March 24, 2023

RE: Comment Response Letter
SUB22-008 (Chase Lot Line Revision)
Updated Request for Information #1
4467 and 4525 Forest Ave SE

Planning Review:

| 129-22 | 09/21/2022 | 0 | 2 OF 2 |

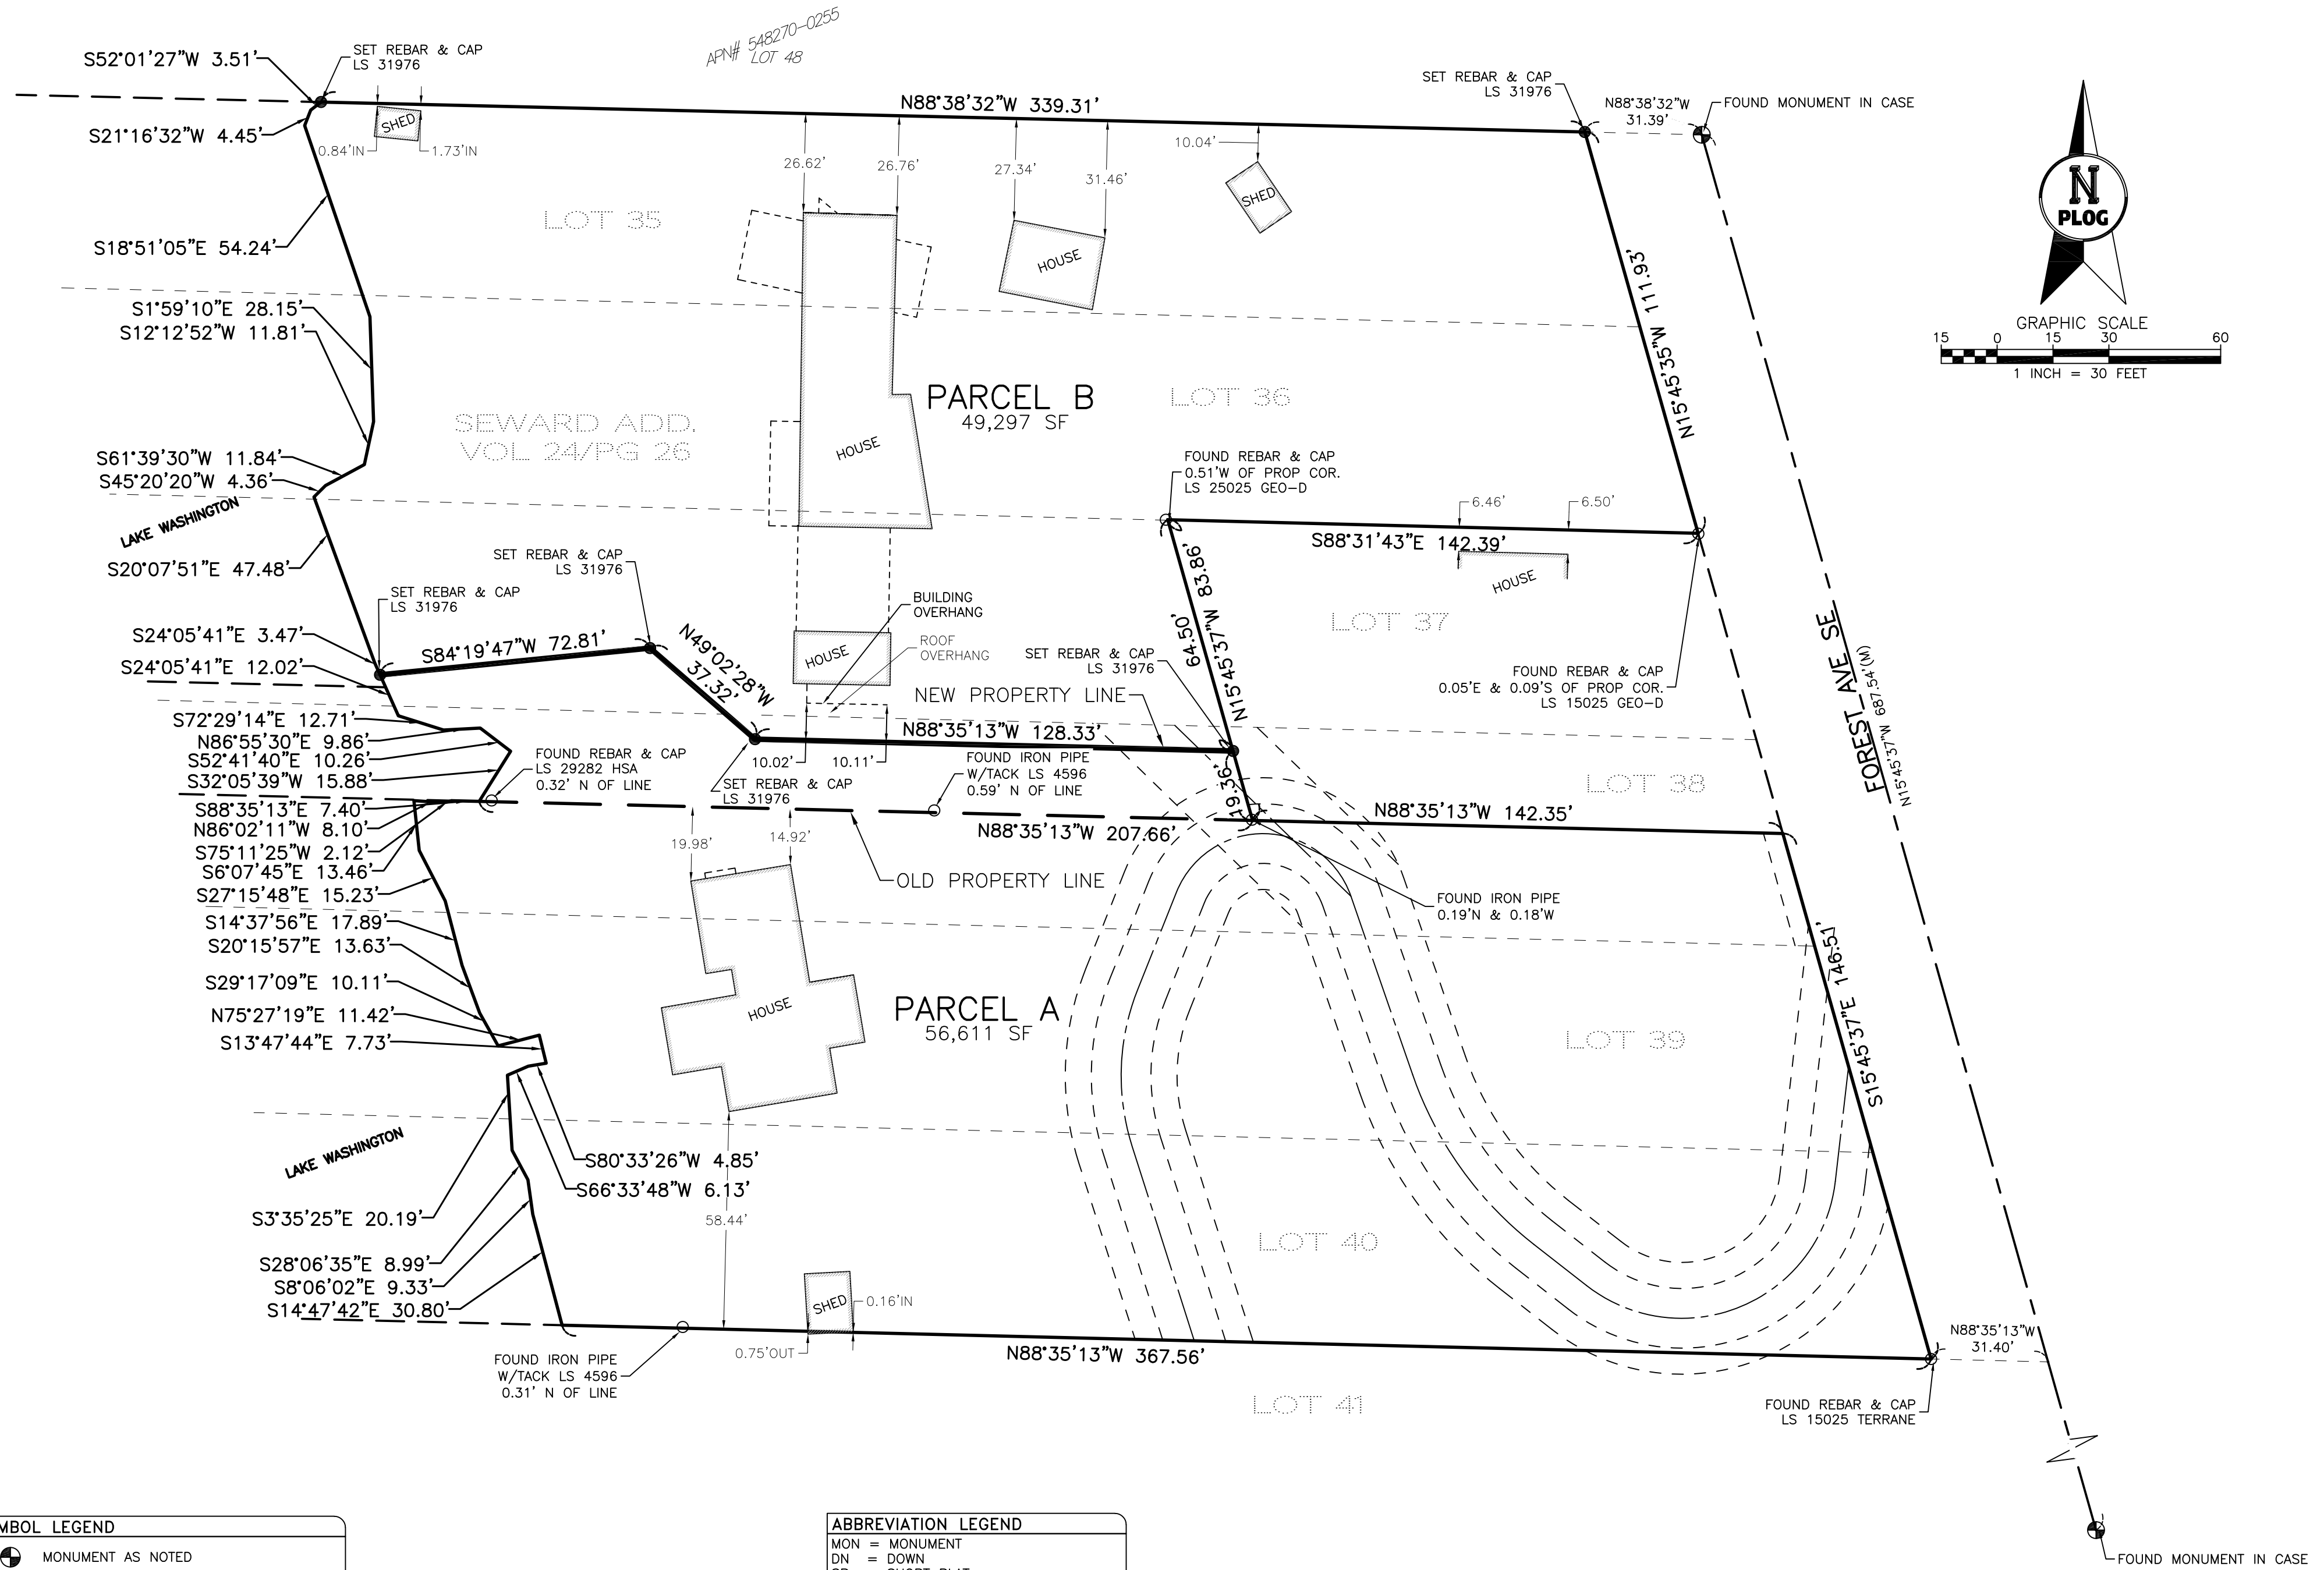
1. Please show all existing recorded easements, including their recording numbers, on the plans.

All easements from the title report are listed on the cover sheet. All easements that are plottable have been shown on the map sheet (page 2) with the easement recording numbers listed.
